Project Name: VALUE PLACE HOTEL

DEVELOPMENT REVIEW BOARD--SPEED MEMO

**CITY OF ALBUQUERQUE, PLANNING DEPARTMENT  
INTERNAL MEMORANDUM**

**RE:** **PROJECT NO. 1004364, Case Numbers 05DRB – 01585, 01586 and 01587, Value Place Hotel – Central SE.**

SHT: 2 OF 6

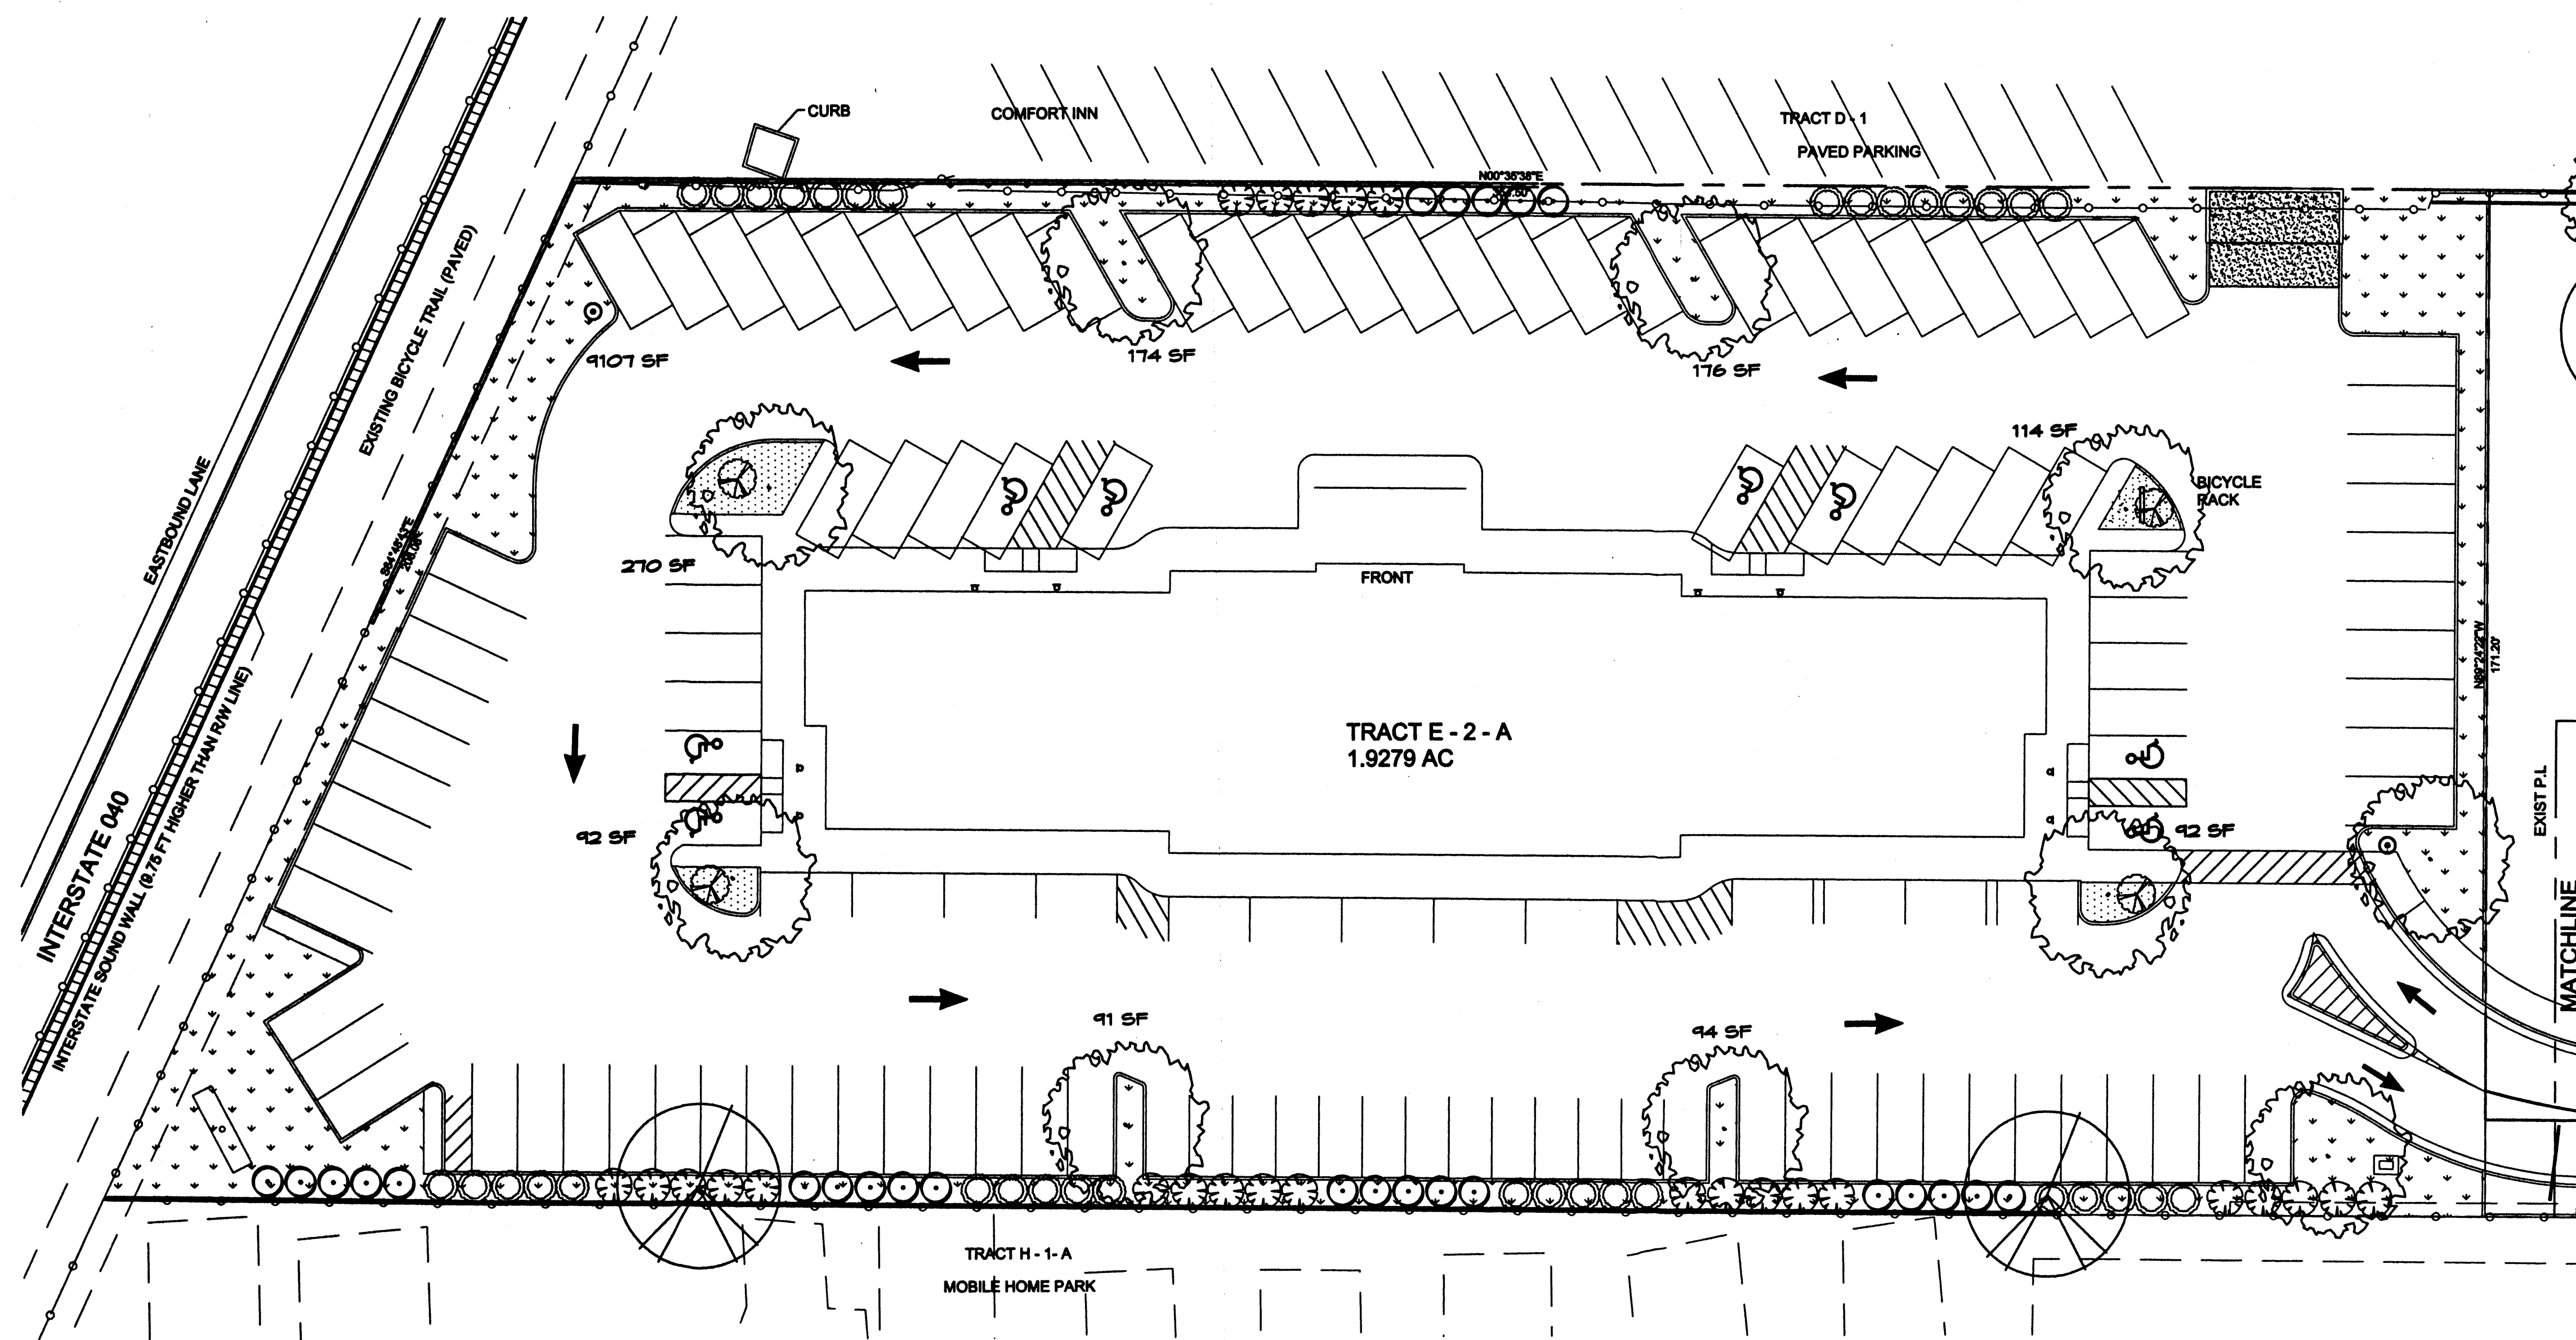
7. With respect to considerations regarding landscaping, the following conditions shall apply:
  - a. The final site plan shall include adequate opaque screening along the west side of the project site, particularly where the project site abuts the existing mobile home park. This may include, but is not limited to, a 60-40 mix of evergreen to deciduous vegetation along the west property line. A 6-foot high solid wall shall be erected along the west property line for a minimum length of 80 feet as measured from the north-westernmost corner of the overall project site unless the proposed trash enclosure is relocated to an alternative location. **(Dumpster relocated; OK-- Landscape treatments along west side of property not done; applicant has issues about installation requirement)**

- e. The applicant shall remove the provision that reads “Final landscape layout to be determined upon receipt of final grading plan from the site development plan for building permit.” **(Language removed; OK)**
- f. The flowering pear trees originally proposed along the west side of the project site shall be replaced with a more suitable tree that will be both more likely to thrive and provide significant canopy. **(OK, Need to also include evergreen vegetation as well)**

FRONT ELEVATION WITH WALL SIGN  
1/32" = 1'

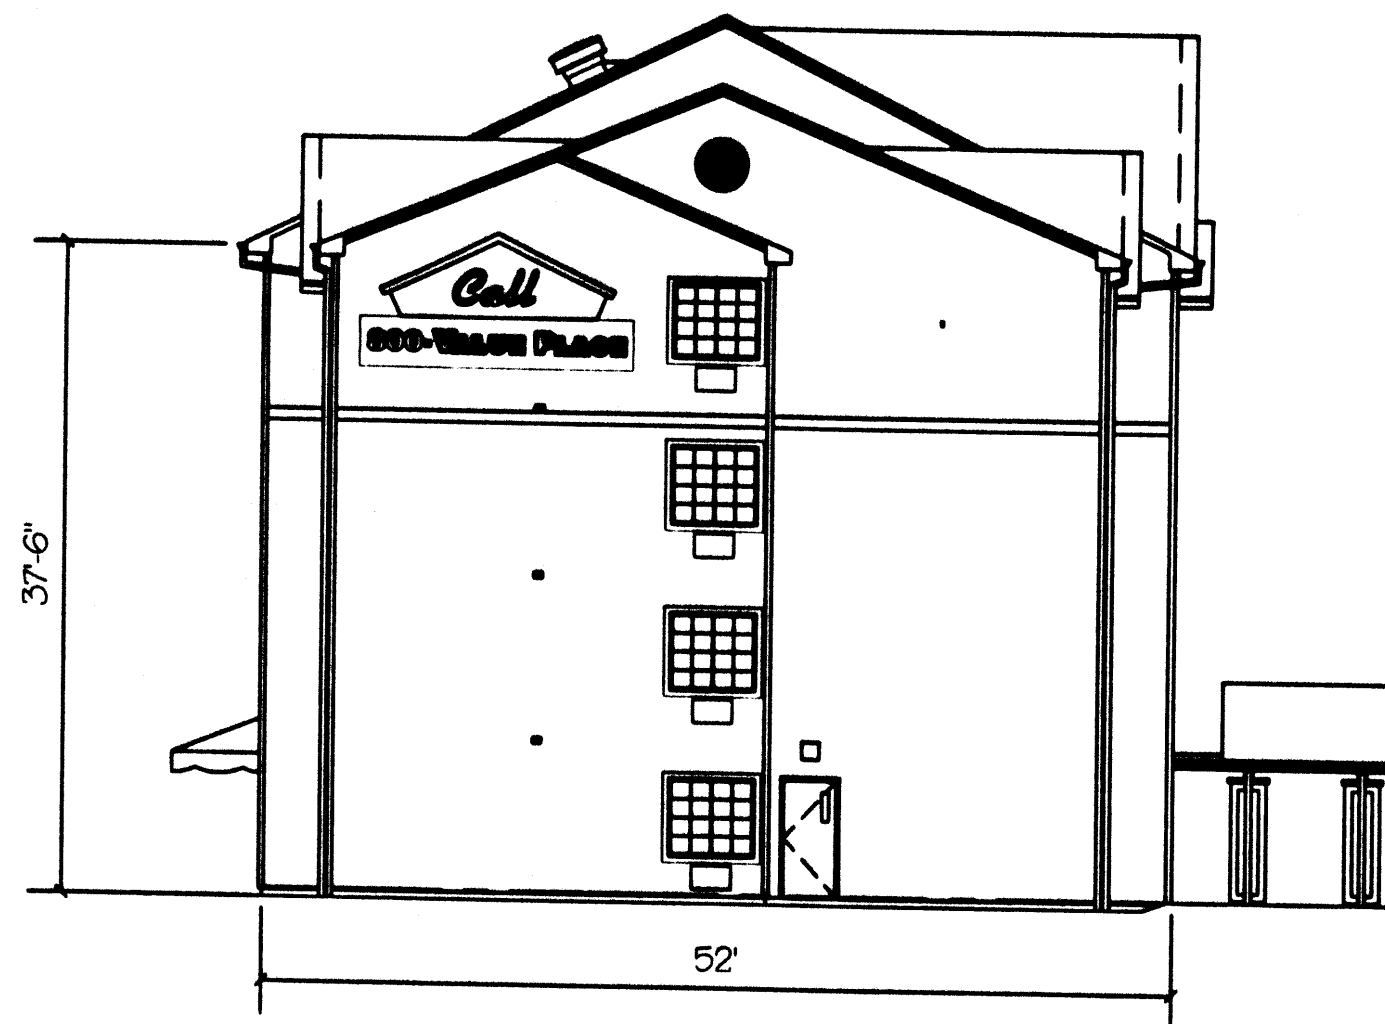
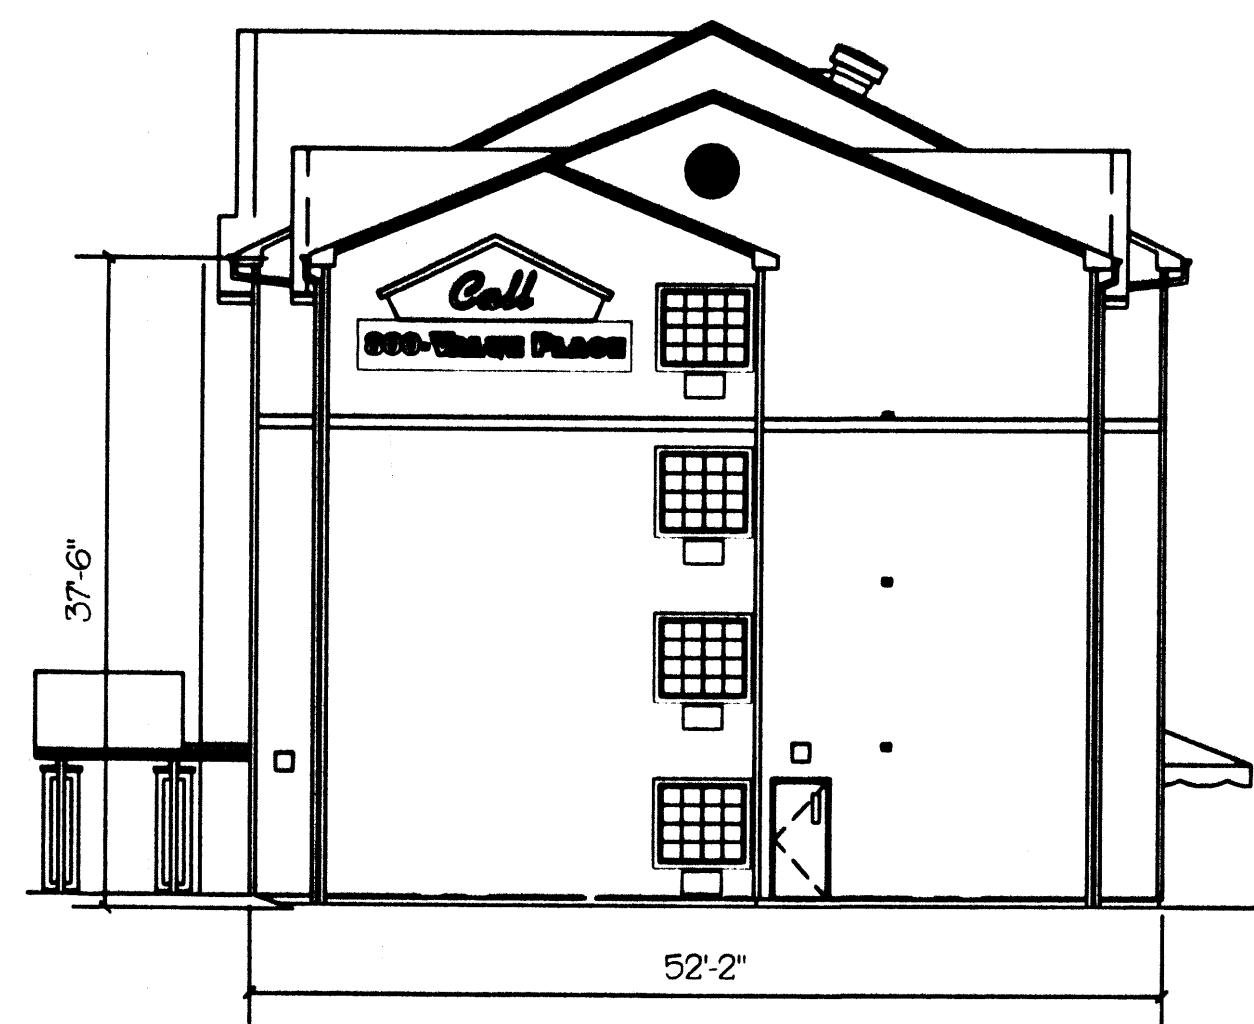
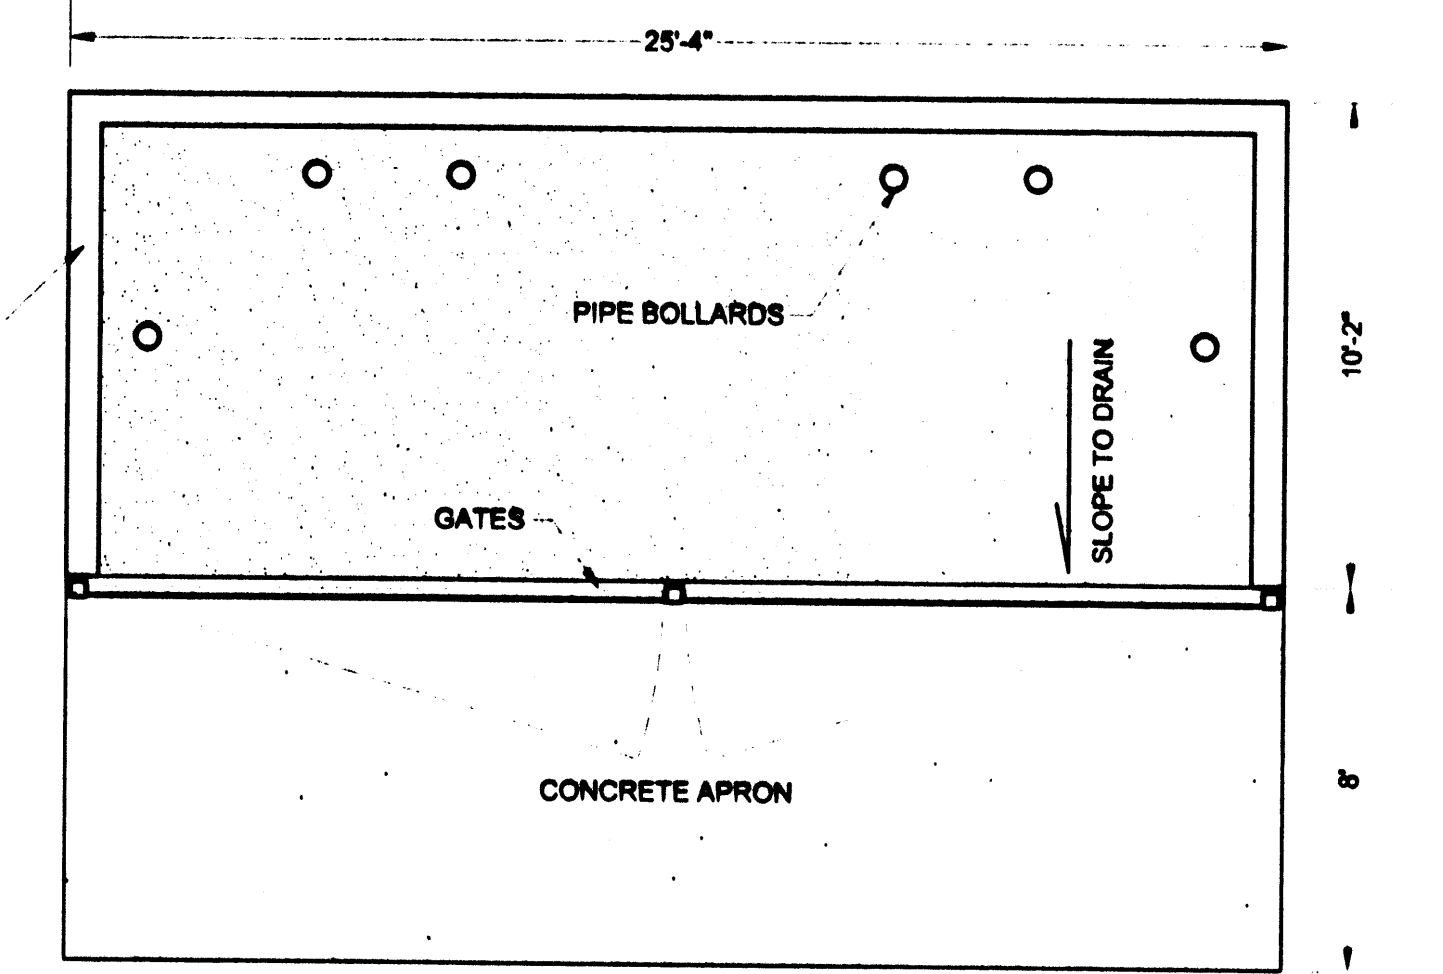
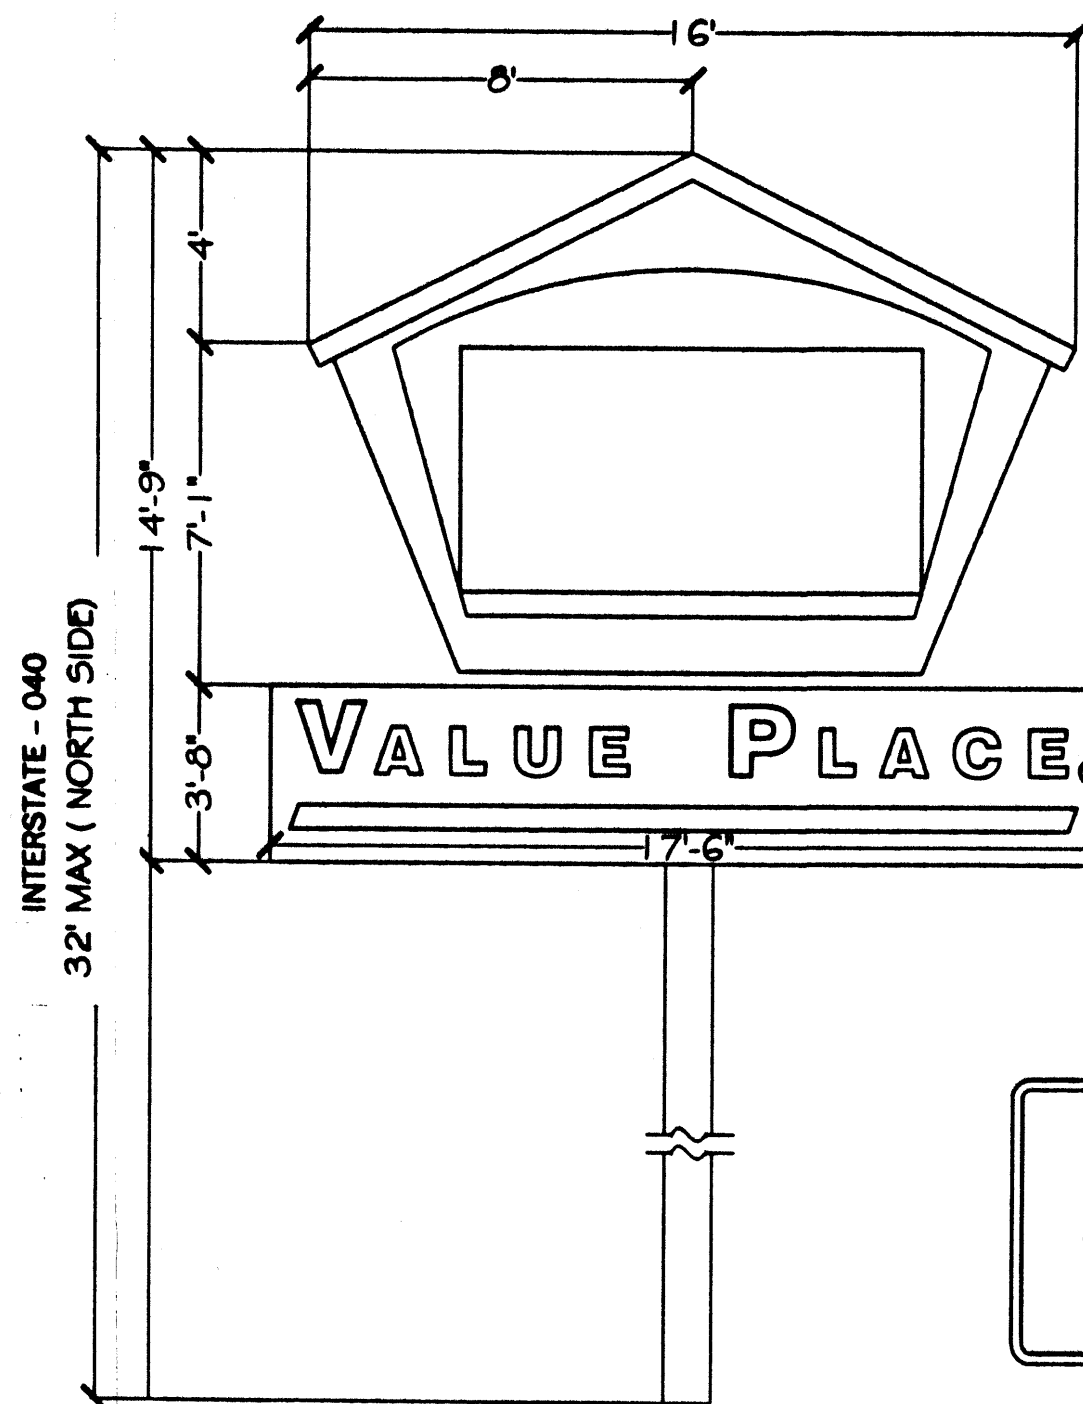
- c. The final site plan shall include either adequate outdoor seating or reasonable alternatives thereof. **(OK)**
  - d. Proposed signage, to include area and dimensions, color and illumination, shall be integrated into the site plan for building permit and not as a separate attachment. **(OK, but applicant needs to clearly differentiate on which frontage proposed signage shall be located)**

REFUSE DUMPSTER ENCLOSURE  
SCALE: 1/4" = 1'

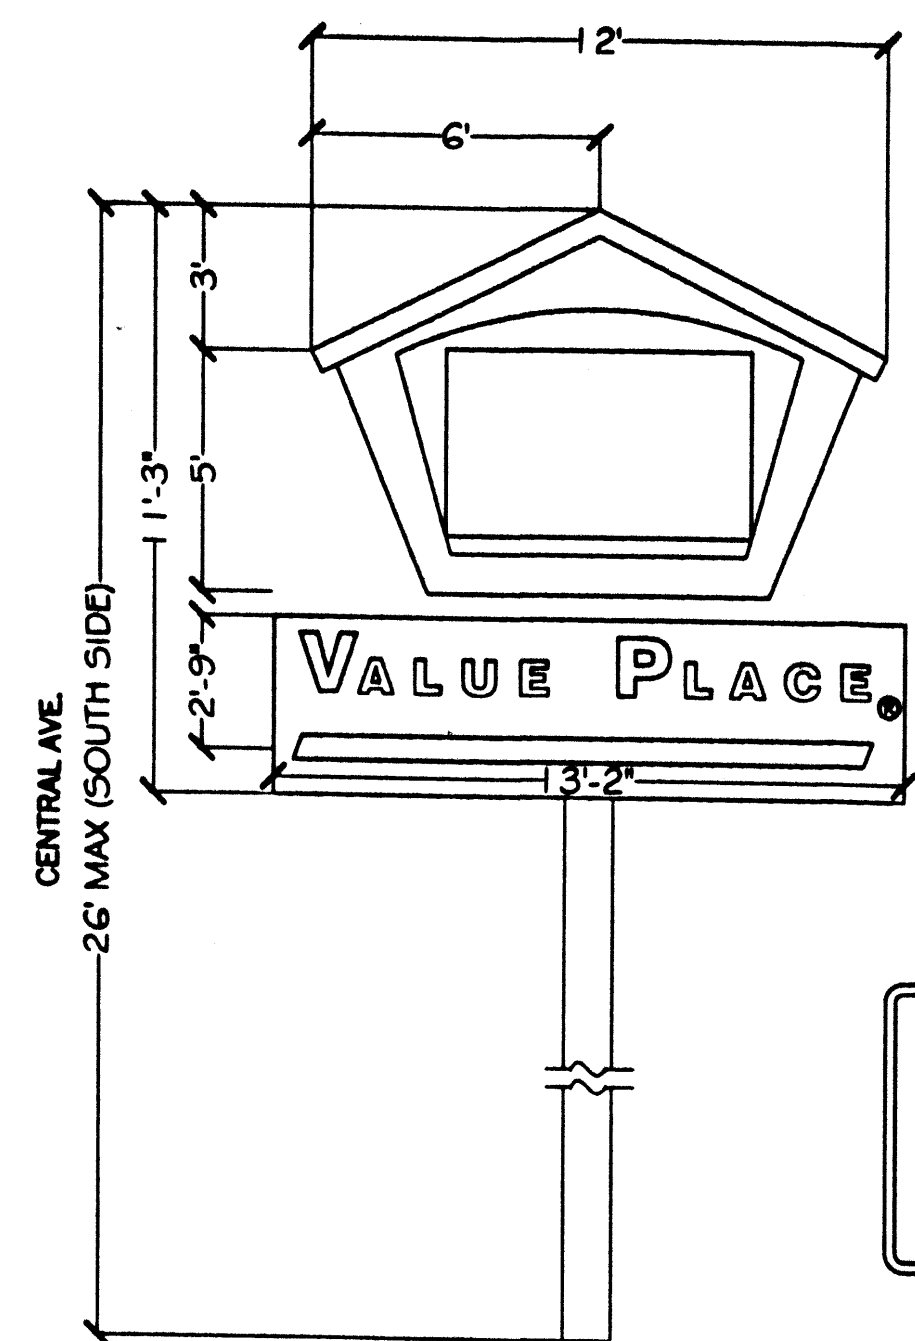
4. With respect to site plan layout and configuration, the following conditions shall apply:
  - a. The final site plan shall include plan-view and cardinal schematics for proposed trash enclosures on site. **(On sh-7, OK)**
